PWCS Terminal 4 Project – Response to Submissions on the Air Quality Assessment

Prepared for:
Port Waratah Coal Services c/o EMGA Mitchell McLennan

Prepared by:
ENVIRON Australia Pty Ltd

Date:
July 2013

Figure F1: Cross-section of Predicted Maximum 24-hour Average TSP Concentrations due to Coal Dust Emissions from Rail Wagons On-route to the T4 project area

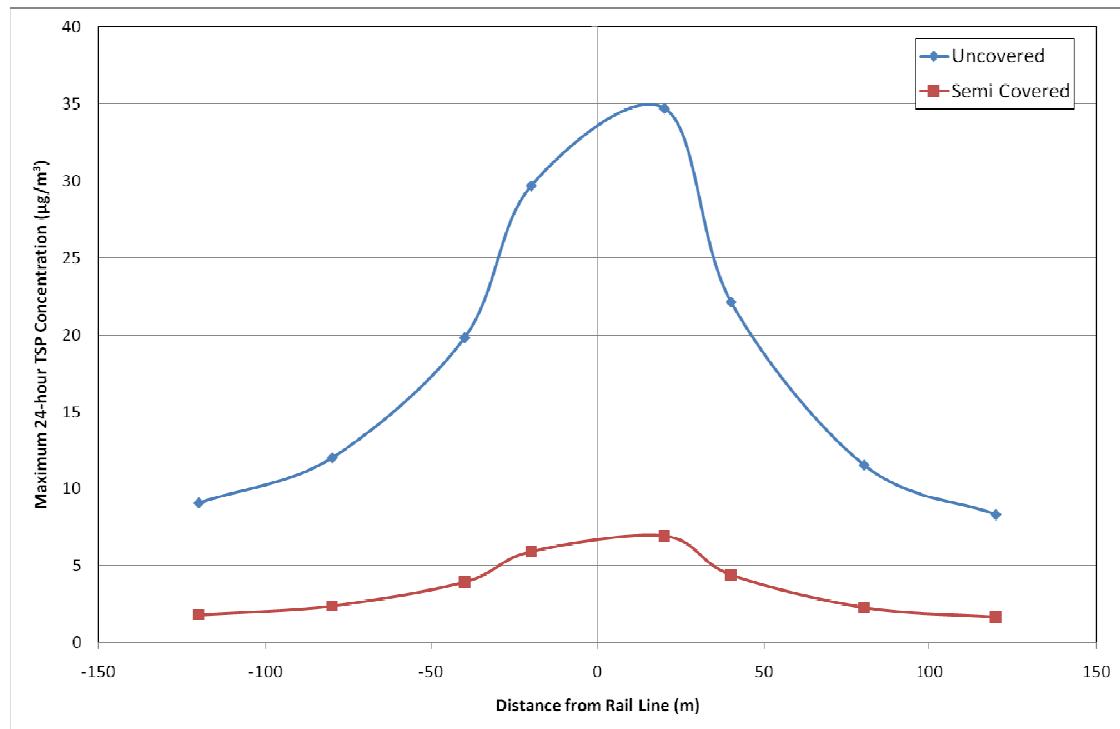
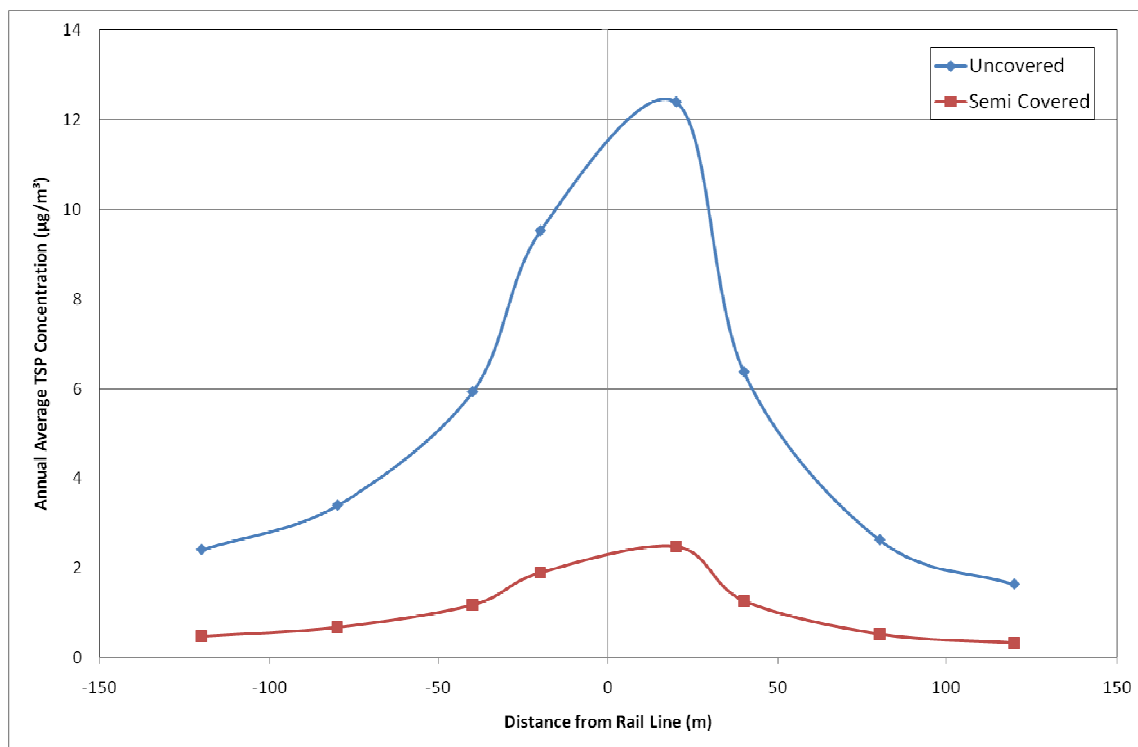
- Only air quality issues around rail transport to the Port are considered, not rail locomotives returning to the Upper Hunter Valley.
- Only rail dust impacts on residences within 20m on the rail line are considered; impacts are likely to extend beyond this.
- Concentrations should be modelled up to 300m from the rail line.
- Concentrations should be modelled within a 2km radius of the rail corridor.

Maximum airborne particle concentrations were modelled to evaluate peak concentrations occurring in the immediate vicinity of the rail line, and the reduction in such concentrations with distance from the rail line. Airborne particle concentrations were modelled at distances of 20m, 40m, 80m and 120m away from the rail line with a significant reduction in concentrations being predicted beyond 20m from the railway line. This assessment is documented in **Appendix F** of the AQIA Report and updated in Appendix O of the RTS/PPR. The study findings were consistent with the findings of the comprehensive Connell Hatch (2008) investigation.

The airborne particle concentrations are predicted to significantly decrease away from the rail line. When discussing the airborne particle concentrations predicted to occur, reference was conservatively made within the main body of the AQIA Report to the peak concentrations predicted in close proximity (within 20m) of the rail line. This is likely to have resulted in the overall assessment approach having been misconstrued.
